DEXUS QUARRYWEST PROJECT (SSD 6801) – SECTION 96 MODIFICATION (MOD 7) – RESPONSE TO SUBMISSIONS

DEXUS Quarry WEST Subtrust (DEXUS) is proposing to modify the development consent for the QuarryWEST Project within the Greystanes Southern Employment Lands. The proposed modification involves changes to the layout of Precincts C and D of the estate. The proposal is described in the Statement of Environmental Effects (SEE) for the proposal dated 18 June 2018.

FIGURE 3A

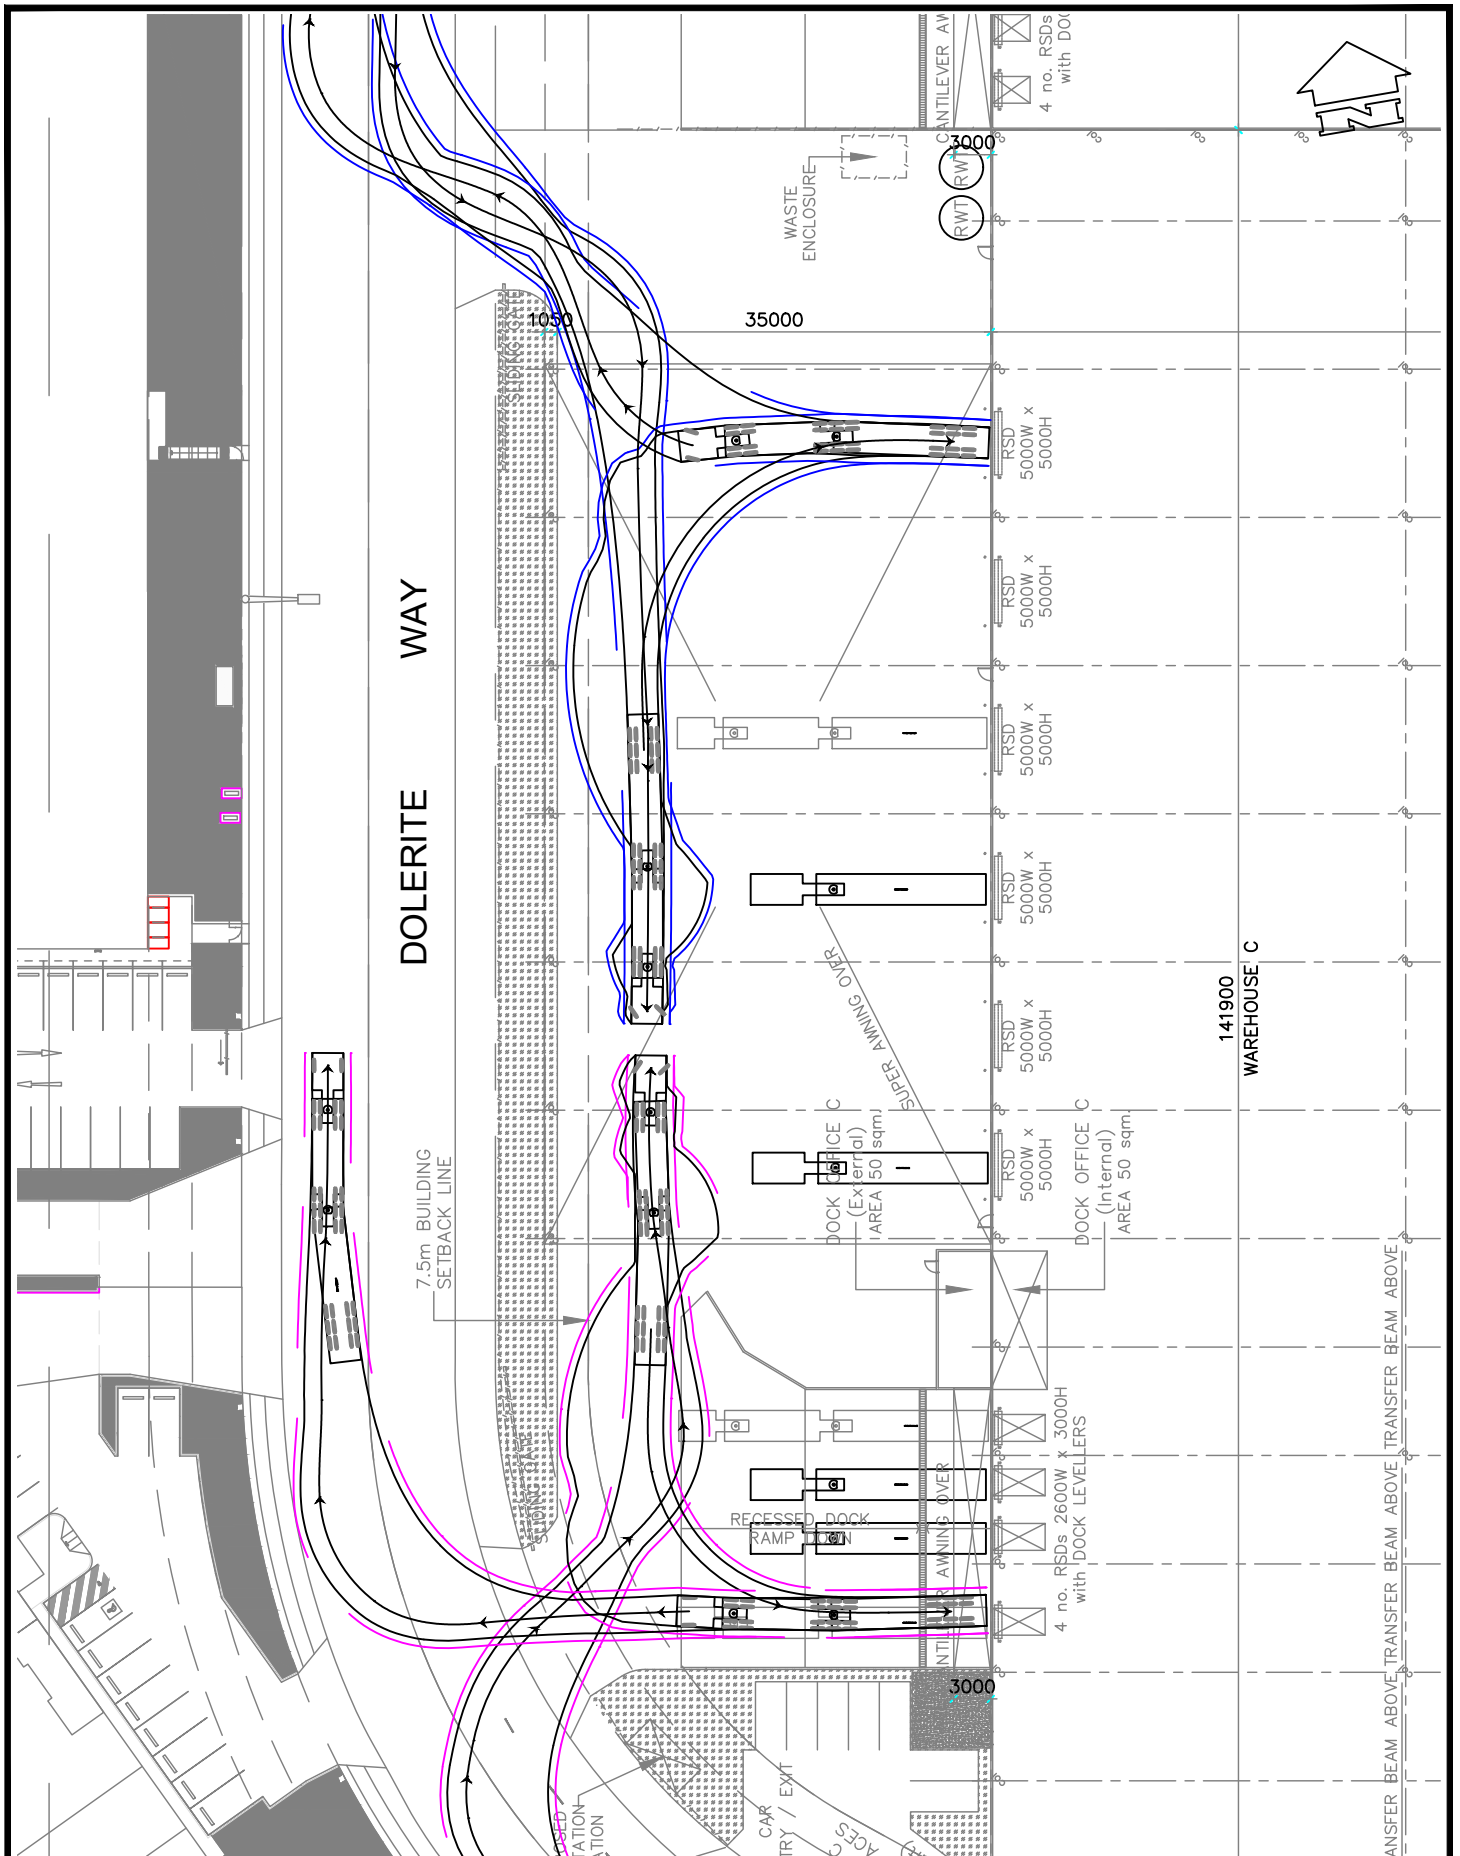
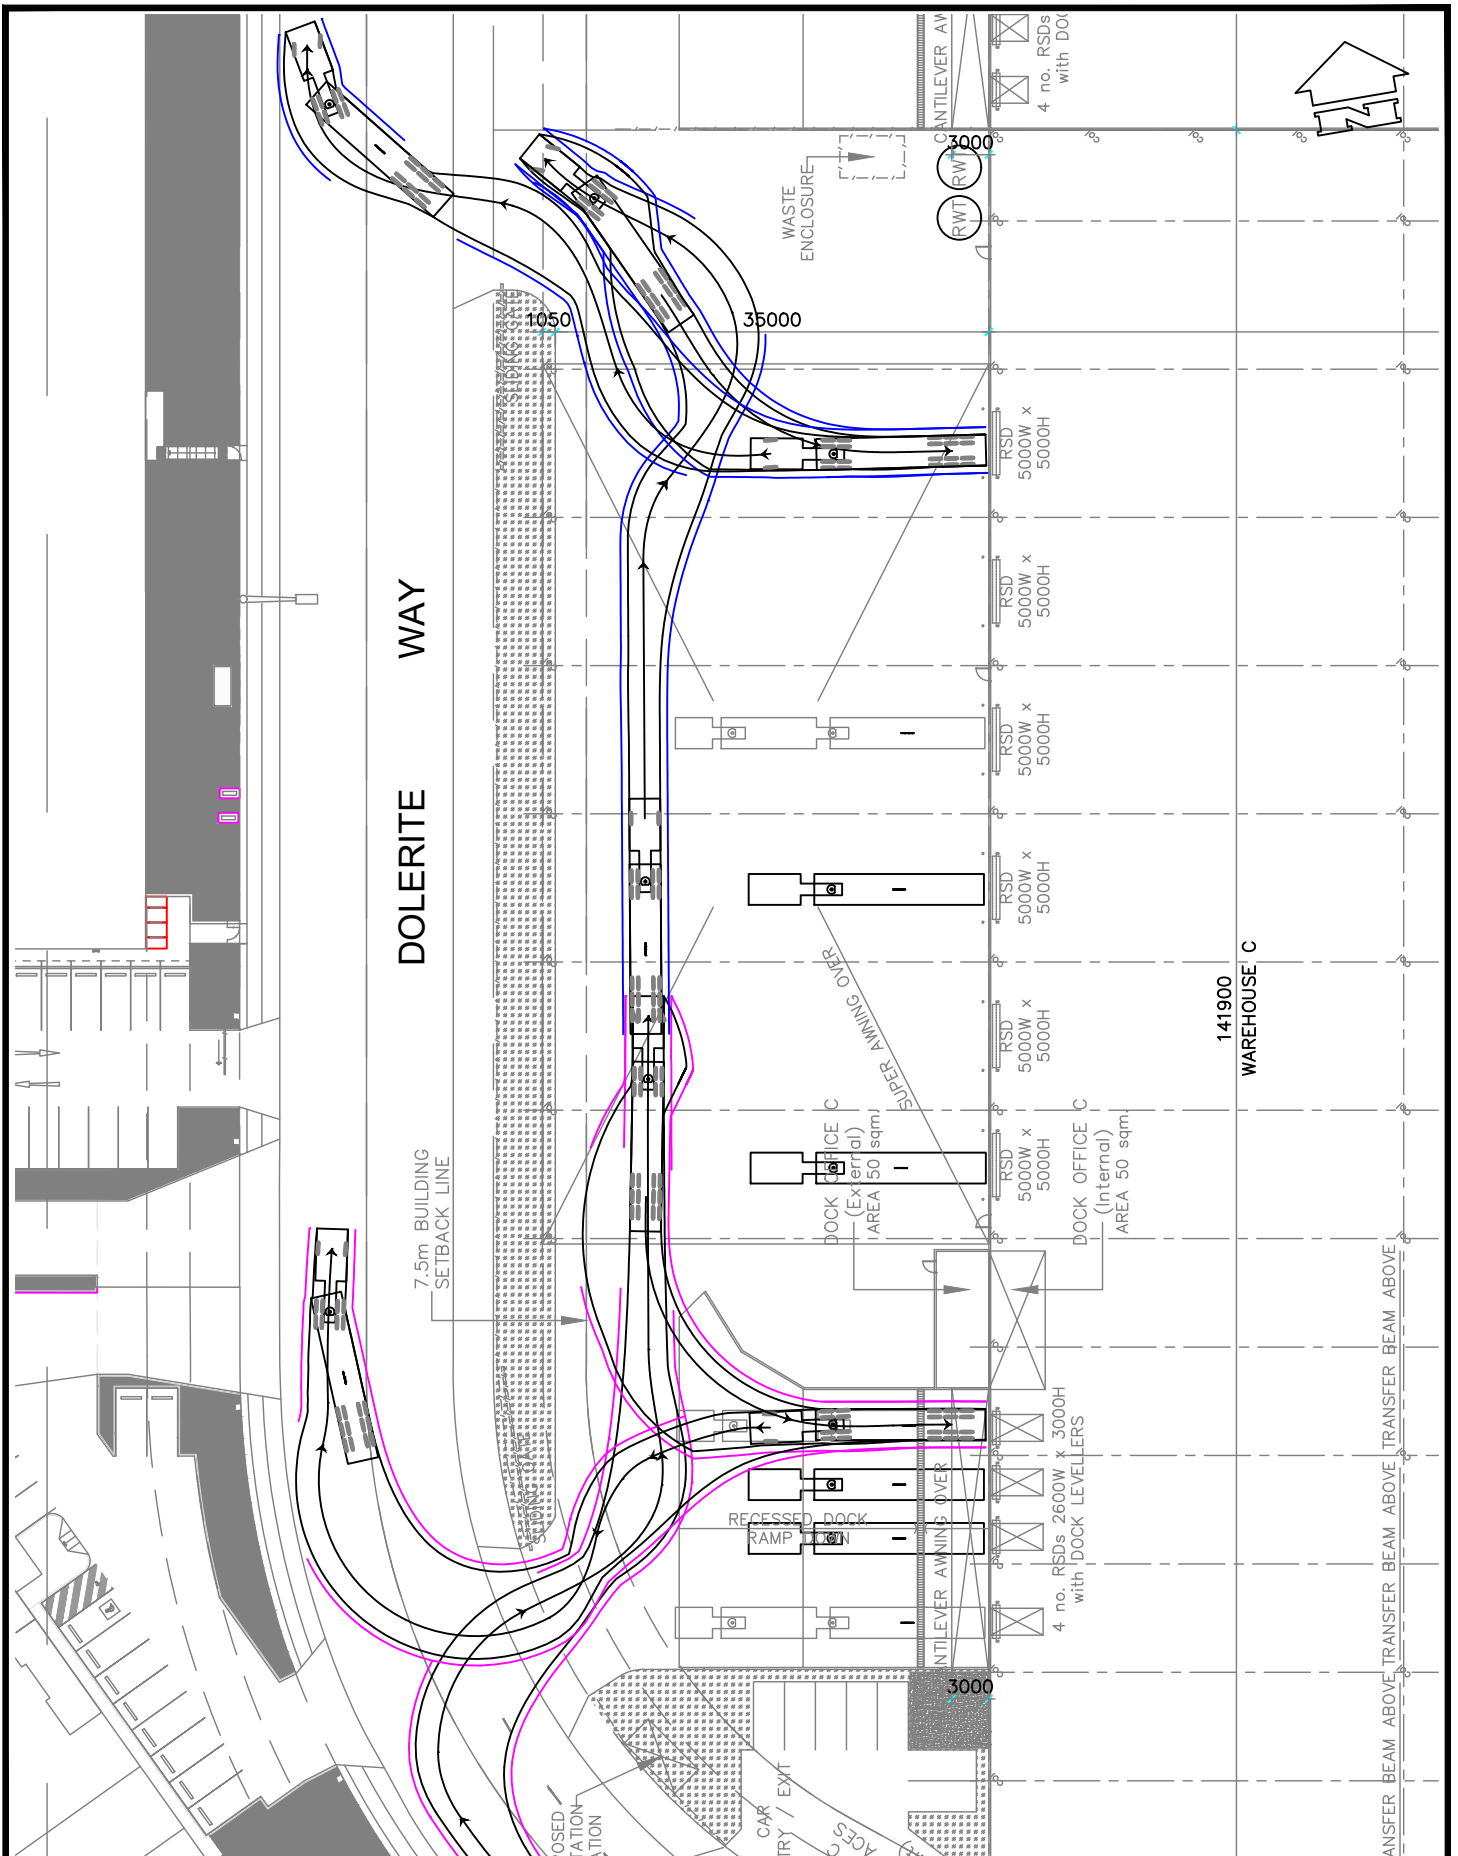
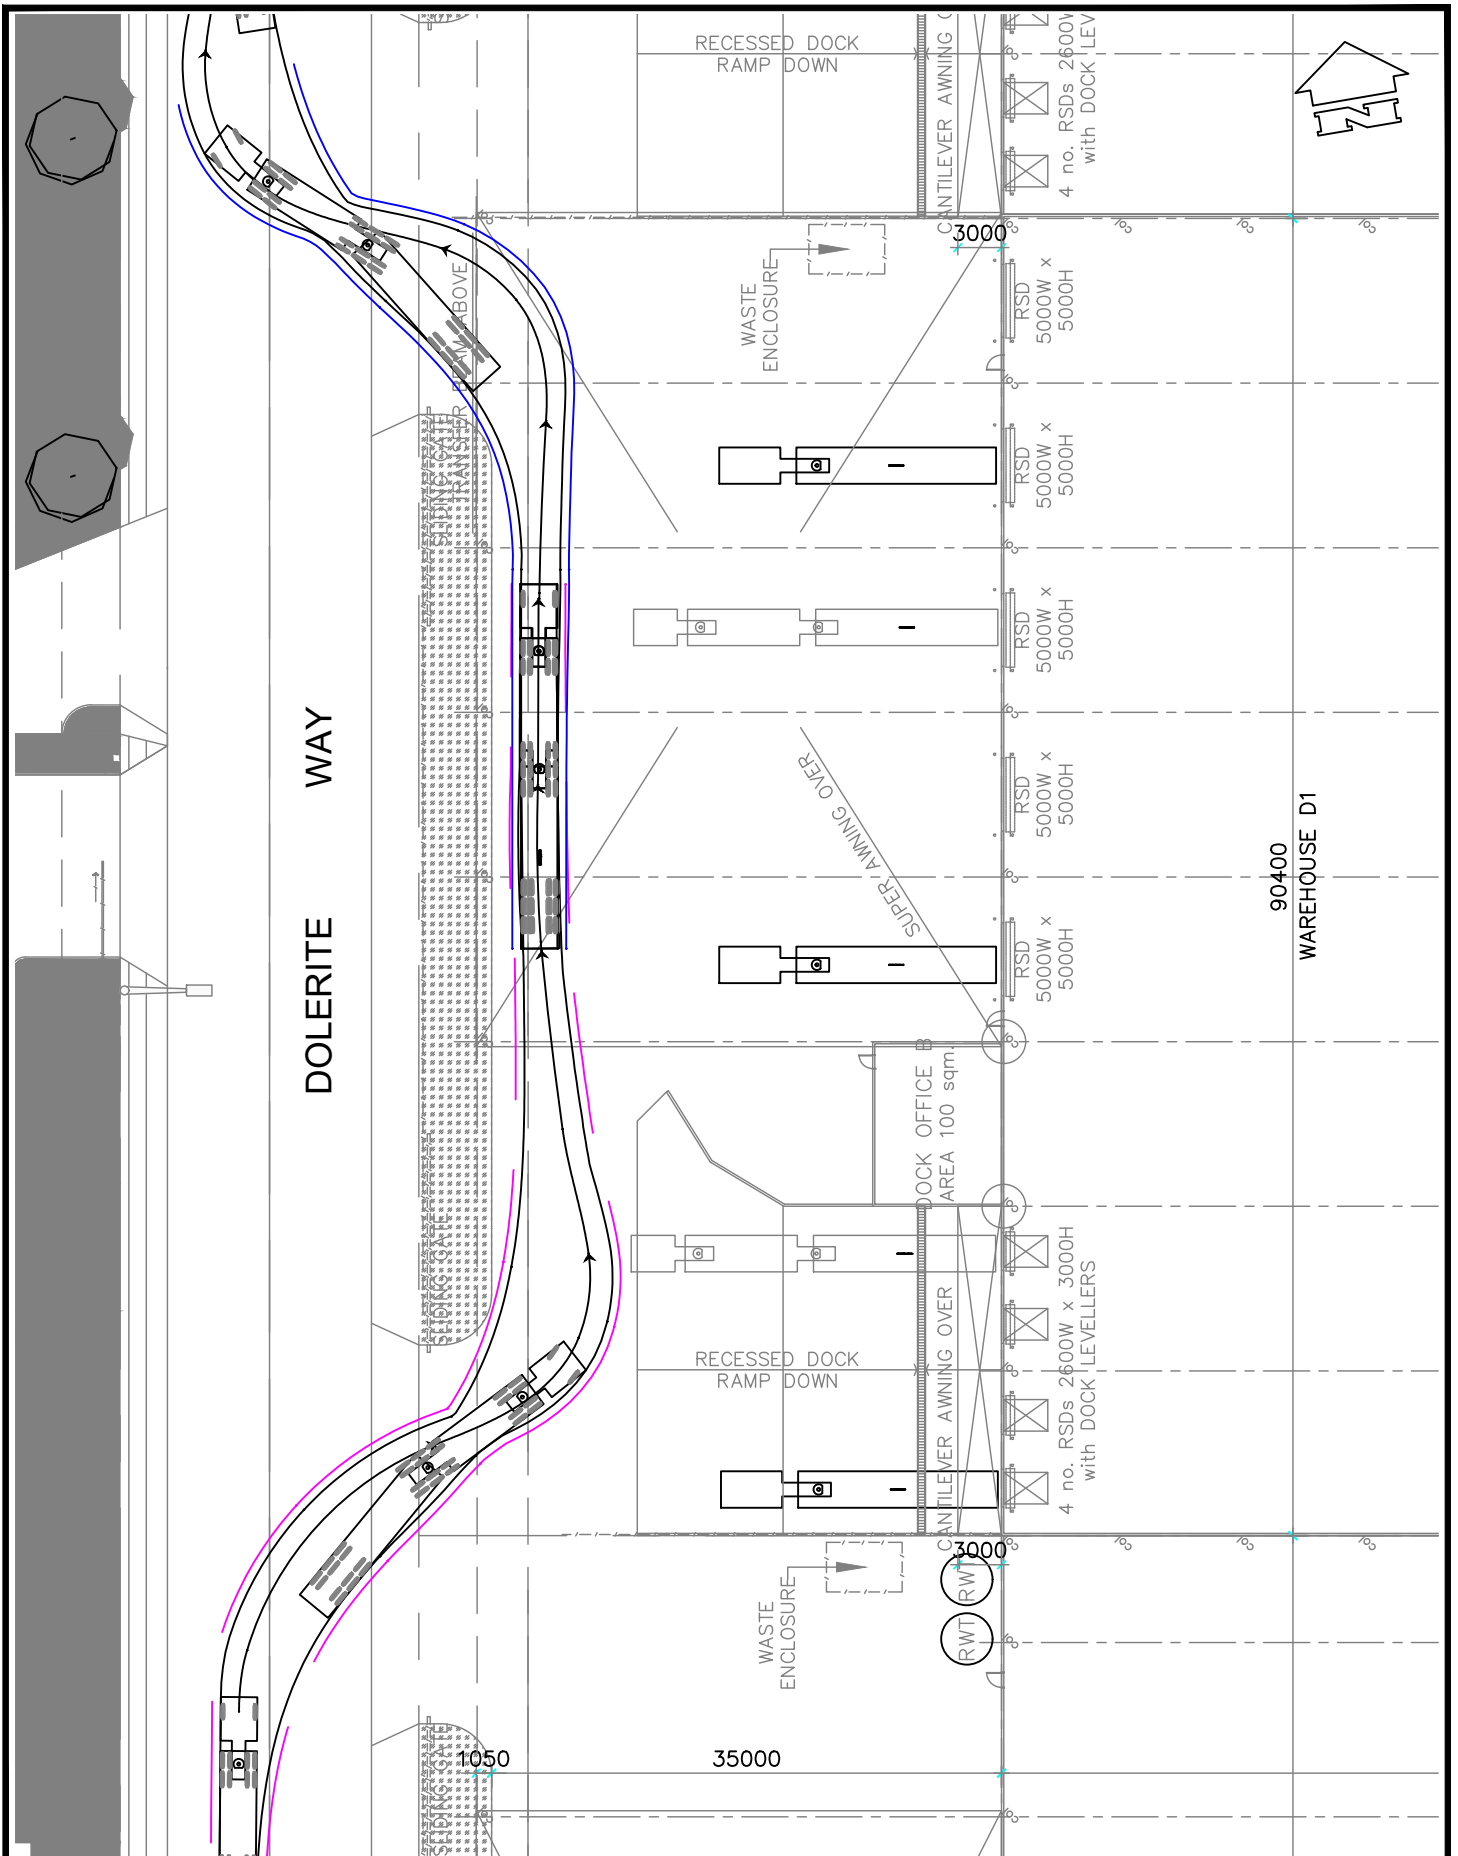
2. Warehouse C driveways	The driveway locations have been reviewed by the project traffic engineer, Transport & Urban Planning (T&UP) (see Appendix C). T&UP notes that proposed driveway for Warehouse C that would be used by trucks on the south western corner of Dolerite Way is in a similar location as the approved building, and meets all the requirements of AS2890.1 and AS2890.2 in terms of location and sight distances to and from the driveway. The driveway for the car carpark is located to the south of the truck driveway on the south western corner. T&UP notes that the sight distance for vehicles entering the driveway is good and complies with AS2890.1. With respect to vehicles exiting the driveway, sight distance to the south, towards Prospect Highway is also good. The sight distance to the north is affected by the curve/bend in Dolerite Way. However, the sight distance meets the minimum requirement for stopping sight distance for the estimated vehicle speeds in Dolerite Way for those vehicles travelling south towards Prospect Highway. Therefore the driveway, in terms of sight distances, complies to AS2890.1 requirements and its location is considered to be satisfactory.
